Date: 06 August 2026

STATUTORY PLANNING CONSULTATION RESPONSE

Application Number:	3/2026/0230
Proposal:	The erection of 60 dwellings comprising houses, bungalows, flats, related infrastructure (including public open space) and landscaping.
Location:	Land to the south of Ribblesdale Primary School west and north of Higher Standen Drive

Drawing file: planx_downloads / 26_0230_P26127DGCZ1GFDRC0001P05_Drainage_Strategy_Plan_5Aug26.pdf

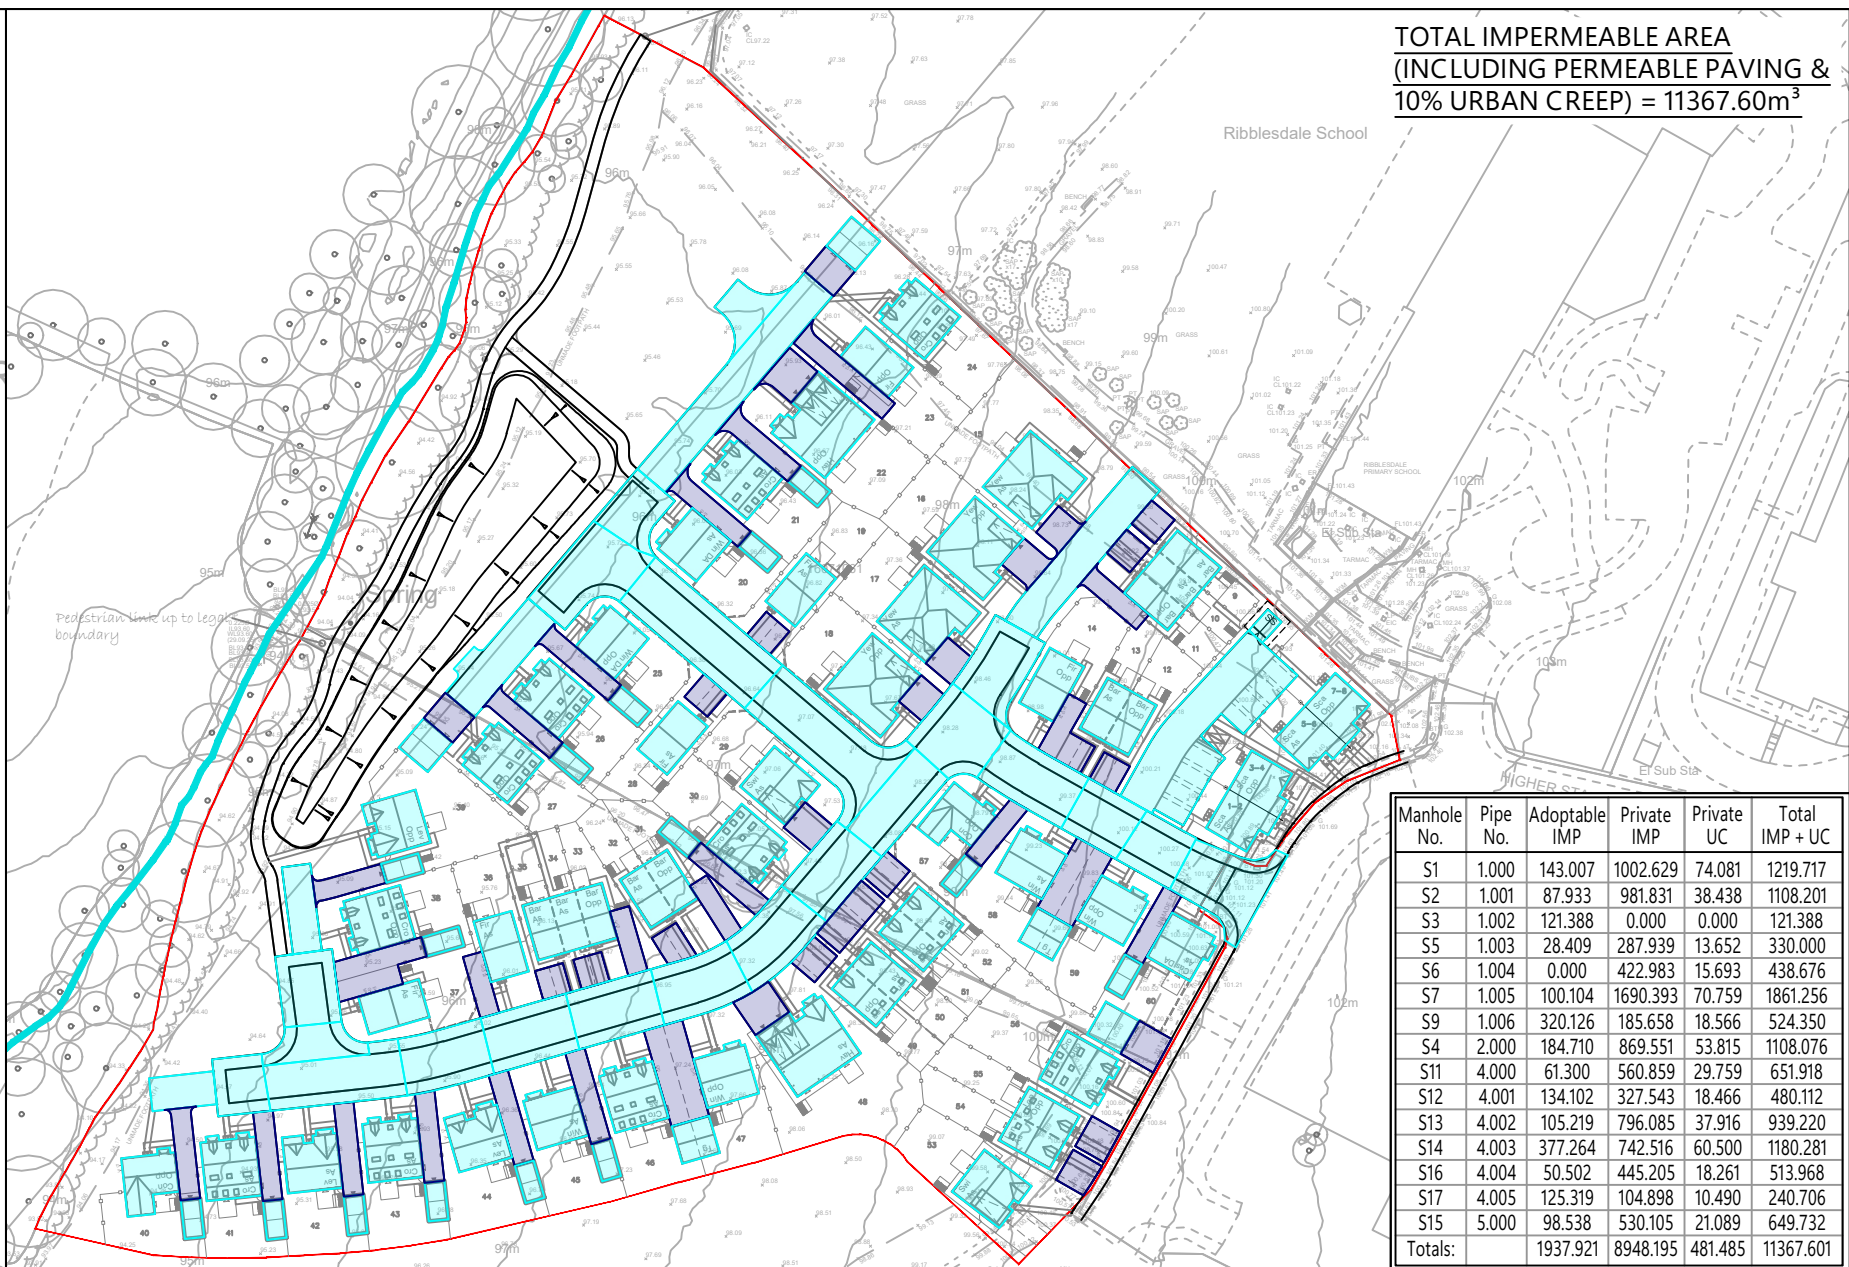
At present the applicant has provided conflicting evidence that states that the contributing impermeable area is 2.05ha whereas the impermeable area plan would indicate that the applicant only intends for an area of approximately 1.16ha will be positively drained.

The applicant must design their SuDS with an appropriate estimation of the area contributing to the drainage system, both permeable and impermeable, with evidence of this area provided through an appropriate contributing area plan, or otherwise demonstrate how surface water runoff from non-drained areas will be managed without contributing to the drainage system and without increasing flood risk onsite or elsewhere.
